WEST SUSSEX COUNTY COUNCIL CONSULTATION

TO:	Arun District Council FAO: Harry Chalk
FROM:	WSCC - Highways Authority
DATE:	15 February 2022
LOCATION:	Wick Information Centre, 76 Wick Street, Littlehampton, BN17 7JS
SUBJECT:	LU/12/22/PL New vehicular cross over. This site is in CIL Zone (Zero Rated) as other development.
DATE OF SITE VISIT:	N/A
RECOMMENDATION:	Advice
S106 CONTRIBUTION TOTAL:	N/A

DROPPED KERB APPLICATION: WICK HALL

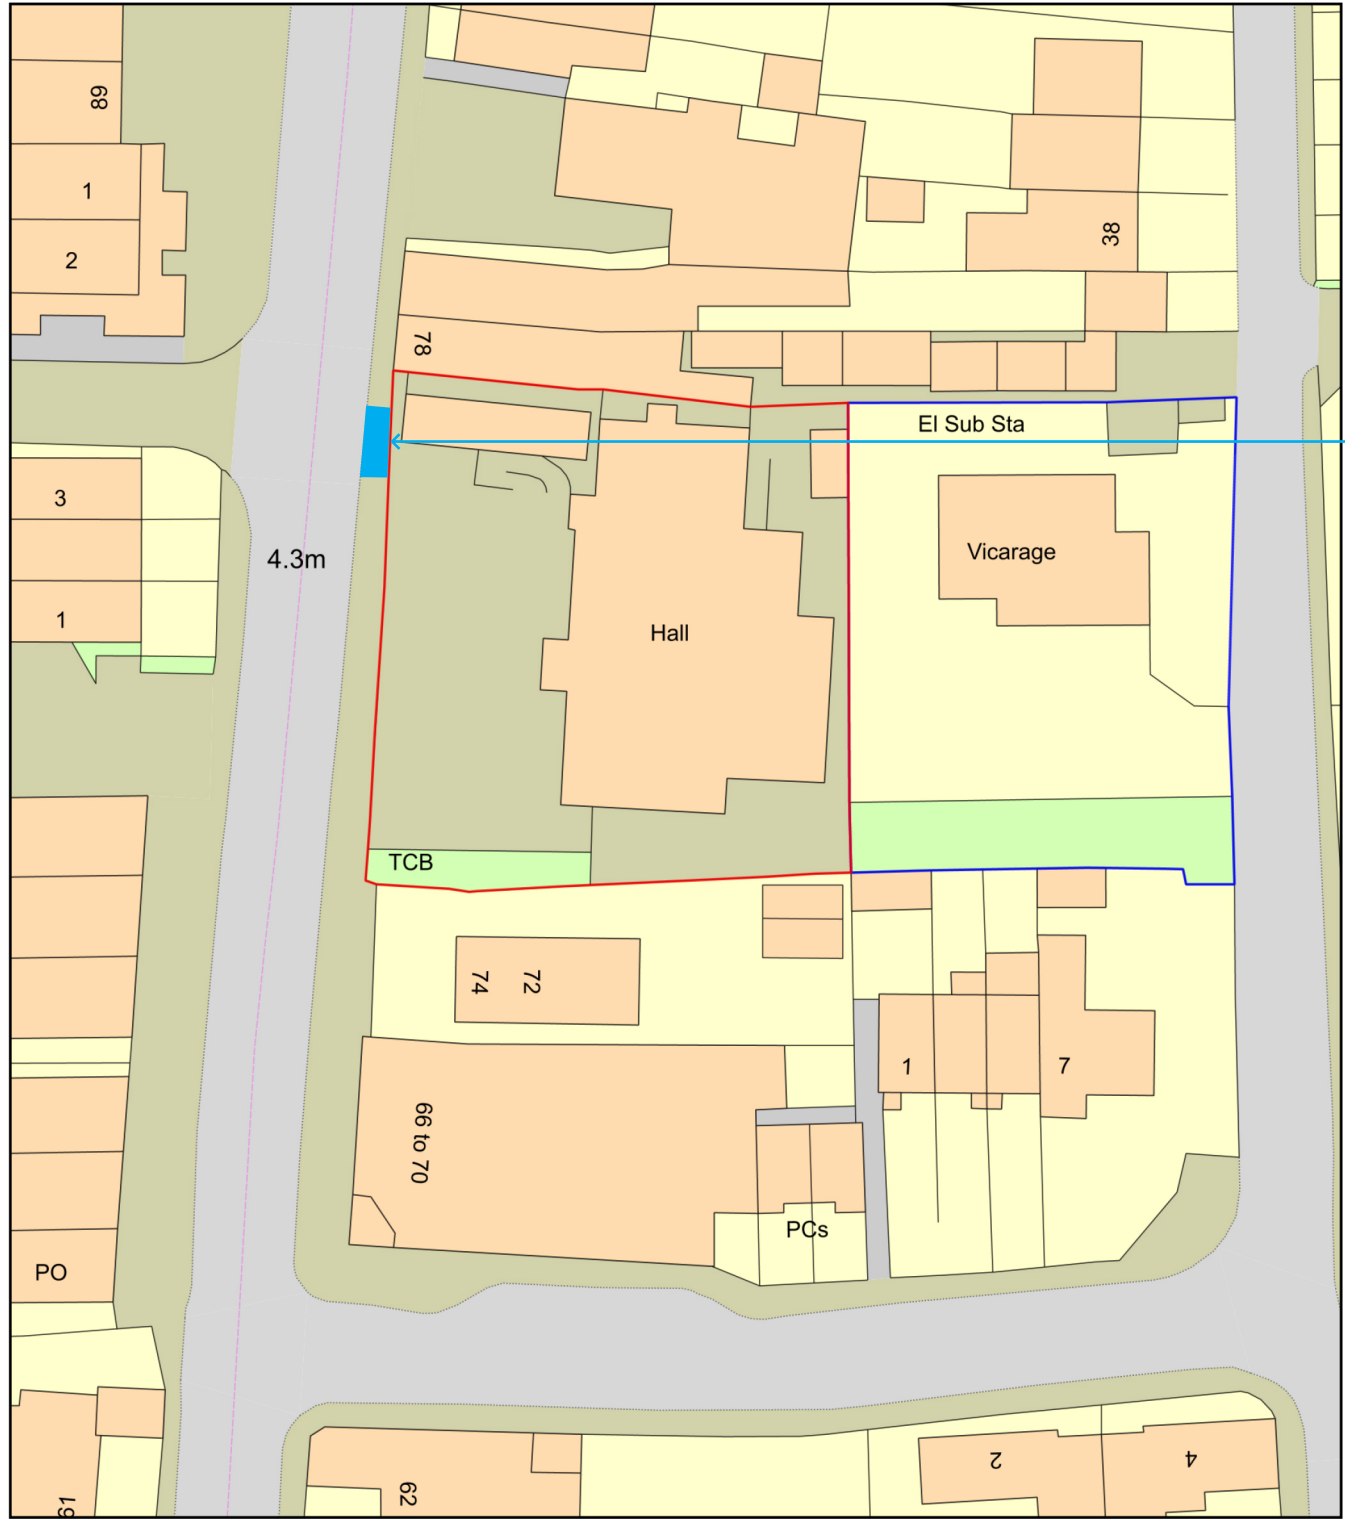
The applicant proposes the implementation of a new 3.5m wide vehicle crossover (VCO), providing a second site access to form an in/out arrangement. The proposed access works will be subject to a licence obtained through the Local Area Office and constructed to a specification agreed with the Local Area Engineer.

Visibility Splay for proposed dropped kerb at Wick Hall, Wick, Littlehampton, BN17 7JS

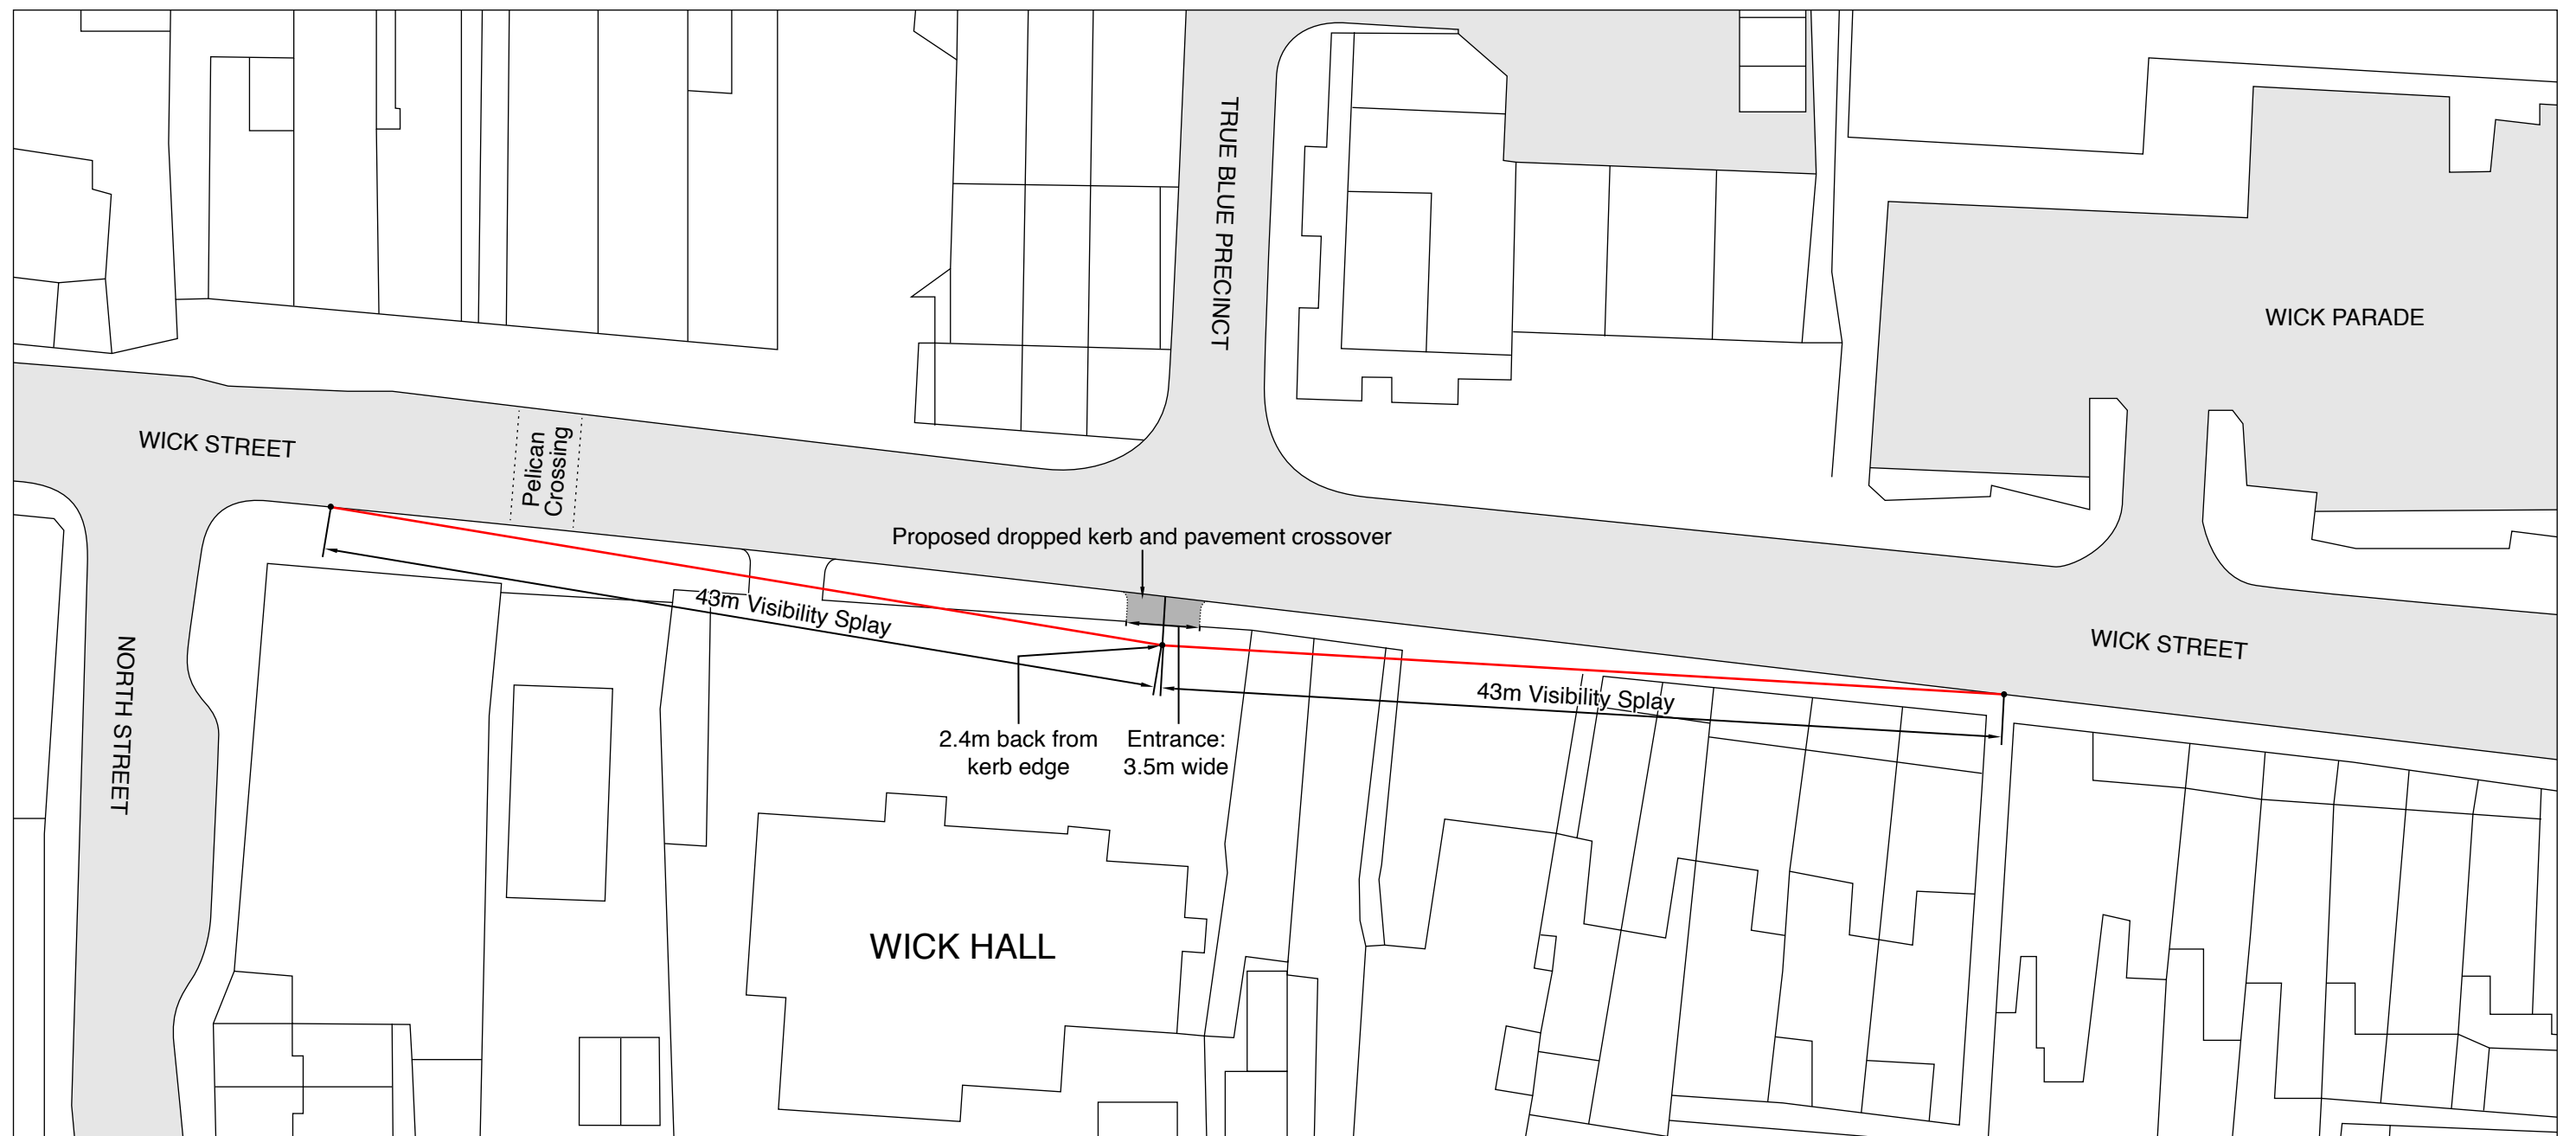
From inspection of the visibility splay plans and local mapping, there are no apparent visibility issues with the proposed point of access on to Wick Street. In addition, the provision of a second access will have a benefit of moving vehicular movements away from the nearby pedestrian crossing.
